June 29, 2021

Re: **Ziggis Coffee**
5200 Menaul Blvd NE
Traffic Circulation Layout
Architect's Stamp **06-04-2021 (H18-D073)**

Based upon our discussion on 06-29-2021 and resubmittal dated 06-25-2021, the above referenced plan cannot be approved for Building Permit until the following comments are addressed:

PROJECT TITLE ZIGGIS COFFEE	PROJECT MANAGER 5200 MANUAL BLVD. NE ALBUQUERQUE, NM	DRAWN BY Project	SHEET TITLE SITE DETAILS
DATE 06-04-21	SCALE	SHEET G4

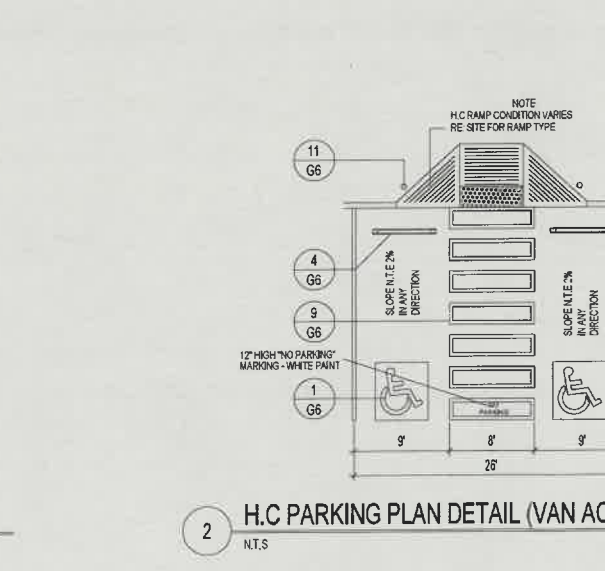
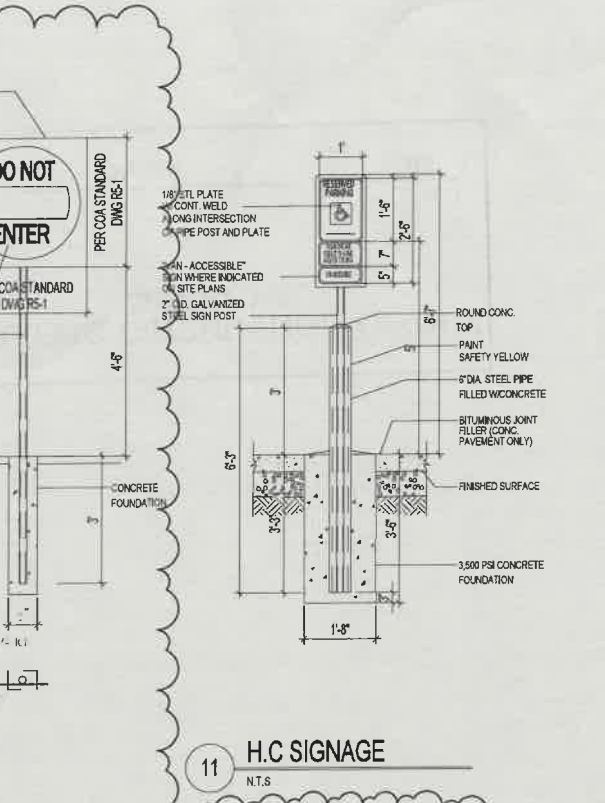
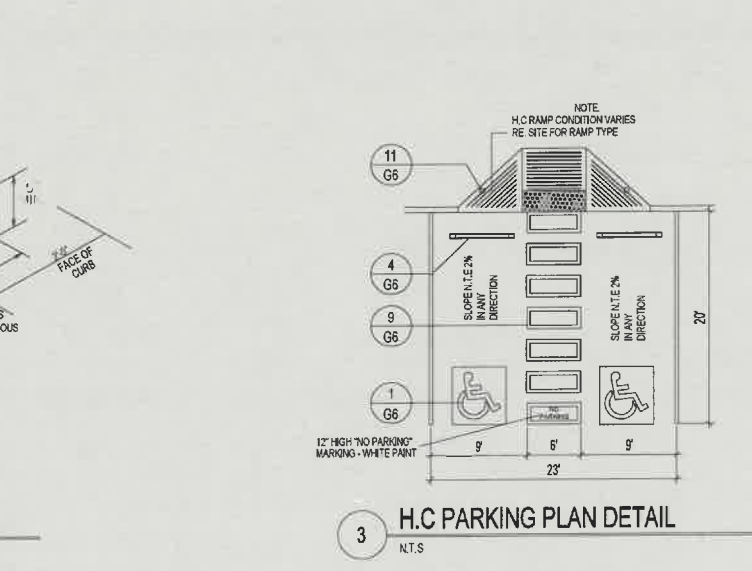
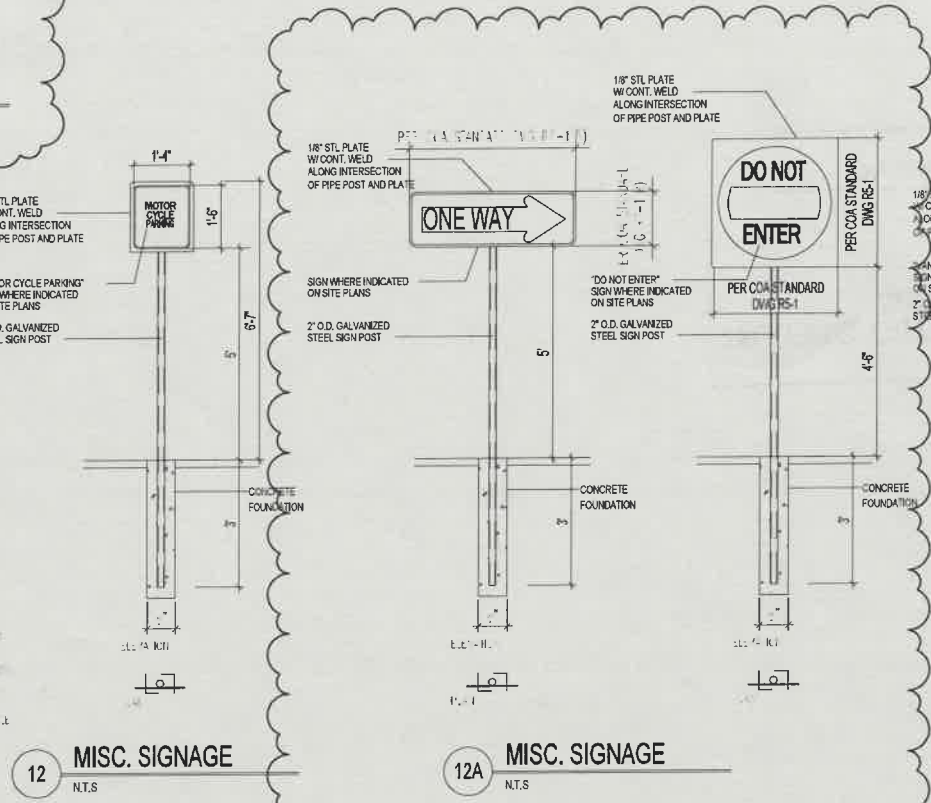
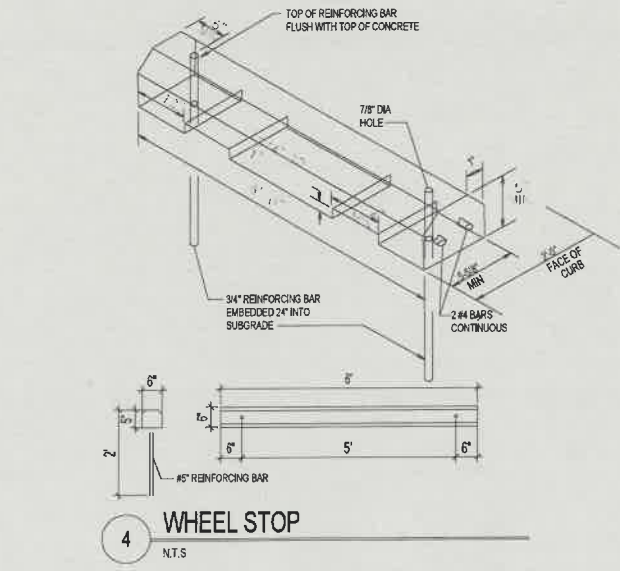
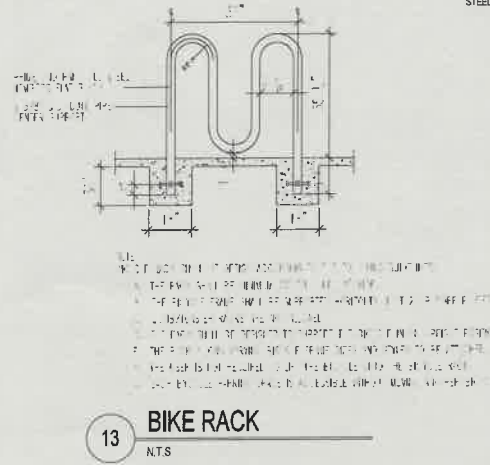
2. **Manual entrance/roadway segment (see G3):**

- The western portion of the driveway is curb return proposed ramp landing will need to be located within the public ROW. If not then provide sidewalk easement.
- The eastern portion of the proposed ramp 12:1 max segment begins at end of radii. So you will need the adjacent land owner permission to accomplish construction on his property.

PROJECT TITLE ZIGGIS COFFEE		JOB NO. 5200 MENAUL BLVD. NE ALBUQUERQUE, NM	
PROJECT MANAGER Project Manager		DRAWN BY: Project Manager	
SHEET TITLE SITE DETAILS		SHEET NO. G6	
DATE 06-04-21	SCALE	SHEET

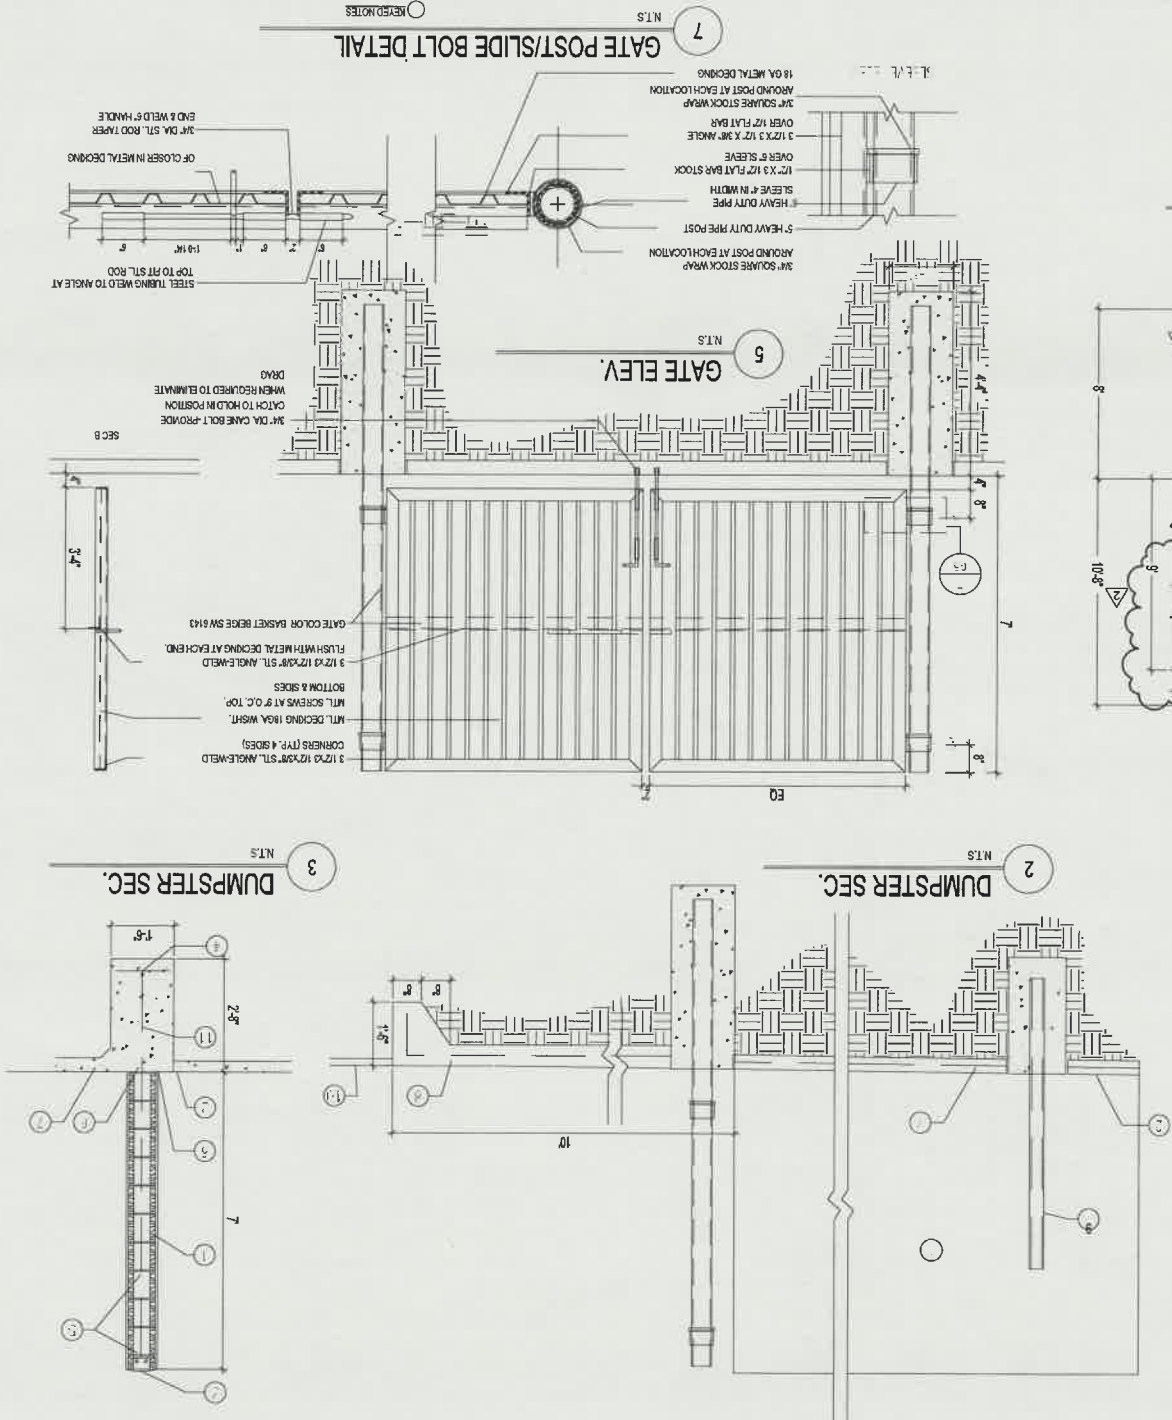
- Modified the entrance per FD requirements and provided FD approval sheet.
- Add signage as shown on attached exhibit. Use R3-2 & R6-1 at San Mateo median in front of proposed entrance (see G3 & G6).
- Add R5-1 on both sides of entrance facing outward (see G3 & G6).
- Add R3-2 & R6-2 facing inward (see G3 & G6).
- Drive aisle of proposed entrance: Move pavement markings are shown on G6.
